From: [REDACTED]
Sent: 14 August 2014 08:42
To: Charlotte Burrows
Cc: 'David Aylott'; mark@abmh.co.uk
Subject: FW: 102 Ancton Way, Middleton - M/41/14/PL
Attachments: F1861 FRA 102 Ancton Way Elmer.pdf

Subject: 102 Ancton Way, Middleton - M/41/14/PL

Unfortunately the application for 102 Ancton Way, Middleton (M/41/14/PL) did not have a Flood Risk Assessment with the submitted information and as the property is within Flood zone 2 & 3 this is required.

EXISTING GROUND FLOOR PLAN 1:100

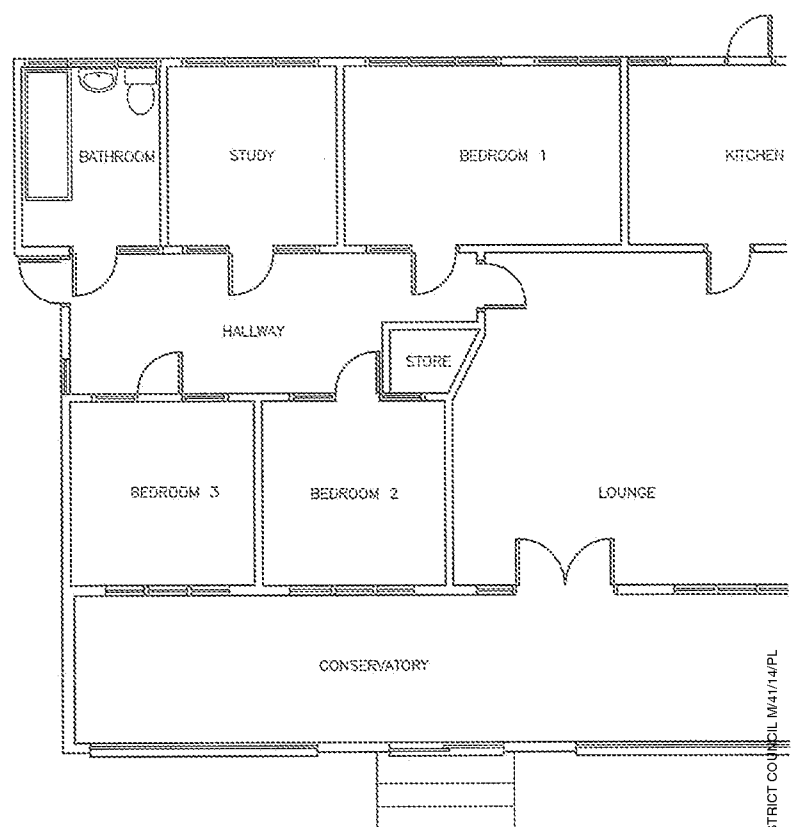
- The fee of £385.00
- revised existing floor plans as there appears to be a window missing from the East elevation.
- The Biodiversity checklist
- Street Scene
